Appeal Decision

Appeal Ref: APP/Z4718/D/24/3338798

12 Inner Hey, Manchester Road, Marsden, Huddersfield HD7 6EL

- The appeal is made under section 78 of the Town and Country Planning Act 1990 (as amended) against a refusal to grant planning permission.
 - The appeal is made by Mr and Mrs Thompson against the decision of Kirklees Council.
 - The application Ref is 2023/62/92740/W.
 - The development proposed is to raise roof height to provide additional accommodation.
-

PROPOSED EAST ELEVATION

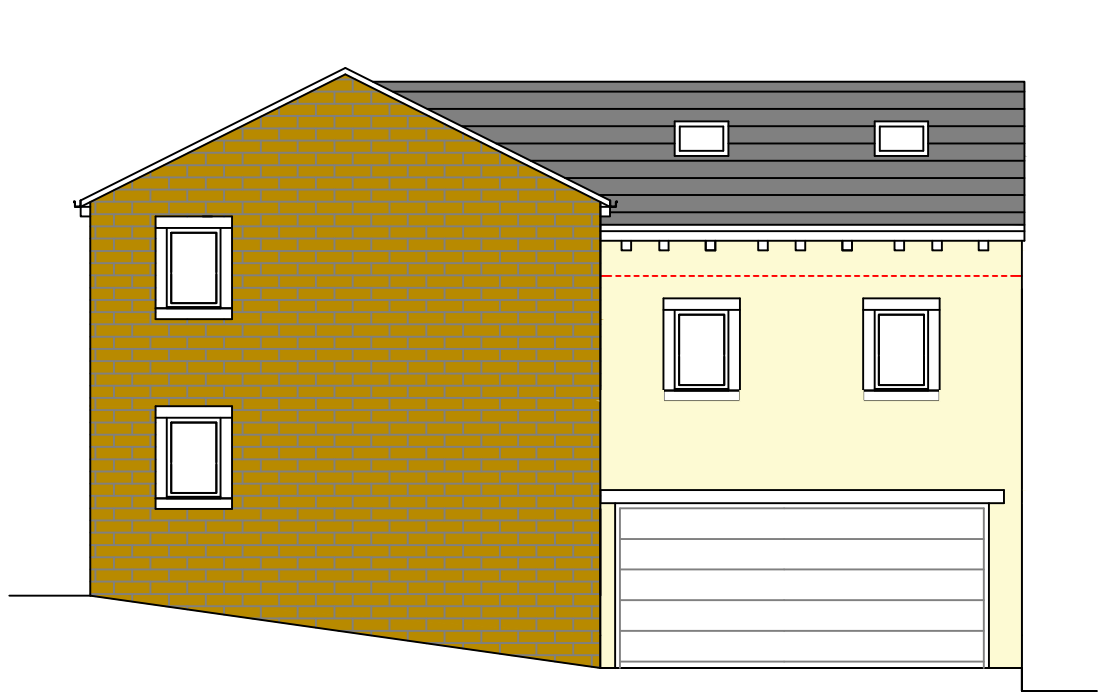
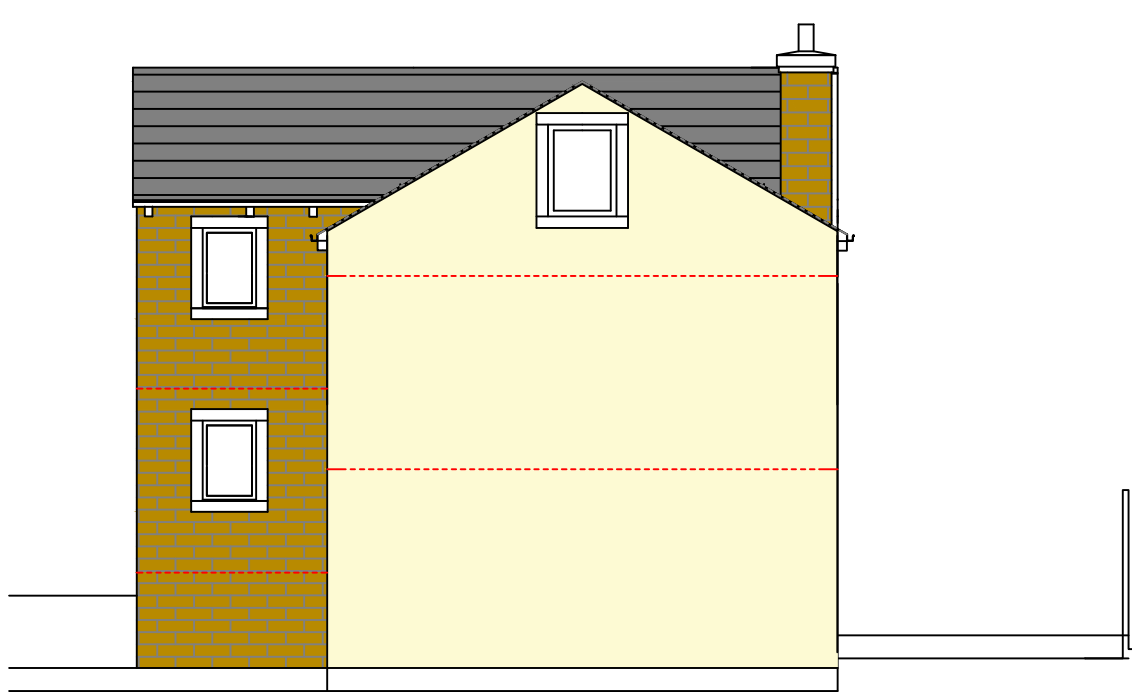
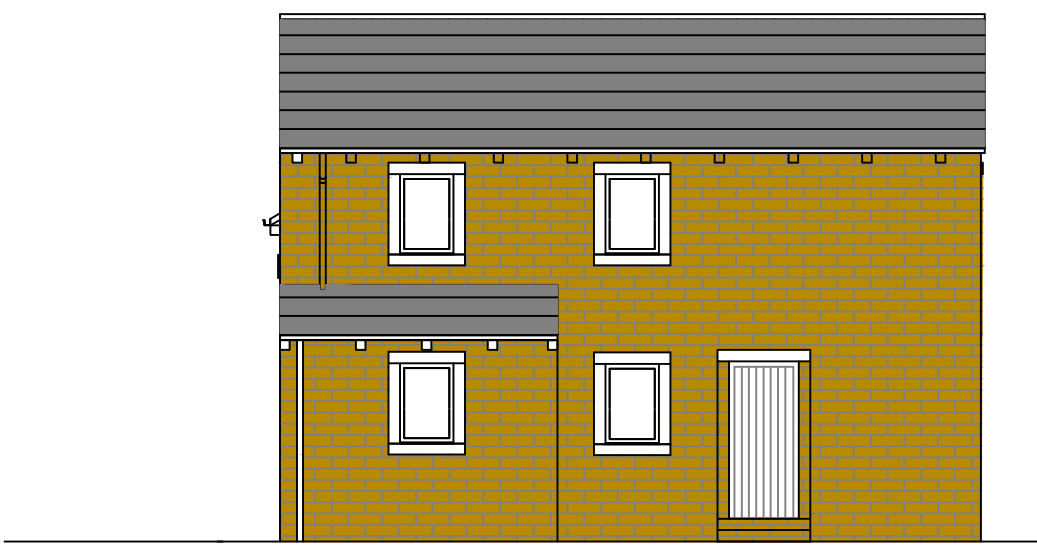
9. It is proposed to raise the roof of the two storey rear element of the property and the height of the existing chimney. The increased ridge height would result in a second floor of internal accommodation. A second floor window would be inserted in the rear-facing gable elevation and the roof would incorporate two small rooflights on each roofslope. These changes would not be clearly visible from Carrs Road, but the proposal would alter the appearance of the building within the Inner Hey street scene and would increase the height of part of the building.

10. However, the street scene along Inner Hey is not uniform due to incremental alterations and additions of varying designs and sizes to the buildings along it and their frontages. The increased height of the appeal building facing towards Inner Hey would result in a moderately larger expanse of rendered elevation which would be clearly visible above the adjacent single storey garage building when approaching the site from Manchester Road due to its position at the highest point of the street. In addition, the eye would be drawn to the proposed window at the apex of this elevation, which would highlight the raised height.

11. Nevertheless, the increase in height would be limited and would remain slightly lower than the main roof, being subordinate to it. Furthermore, the addition of a window would add interest to the otherwise unremarkable blank gable wall. Due to the topography of the area, the roofscape along Inner Hey is staggered. This means that in views along Inner Hey towards the appeal property, in the context of the surrounding varied built form, the proposal would not appear overly prominent. Consequently, having regard to its limited heritage significance and its contribution to the MCA, the proposal would not diminish the quality or integrity of the MCA or result in harm to its significance.
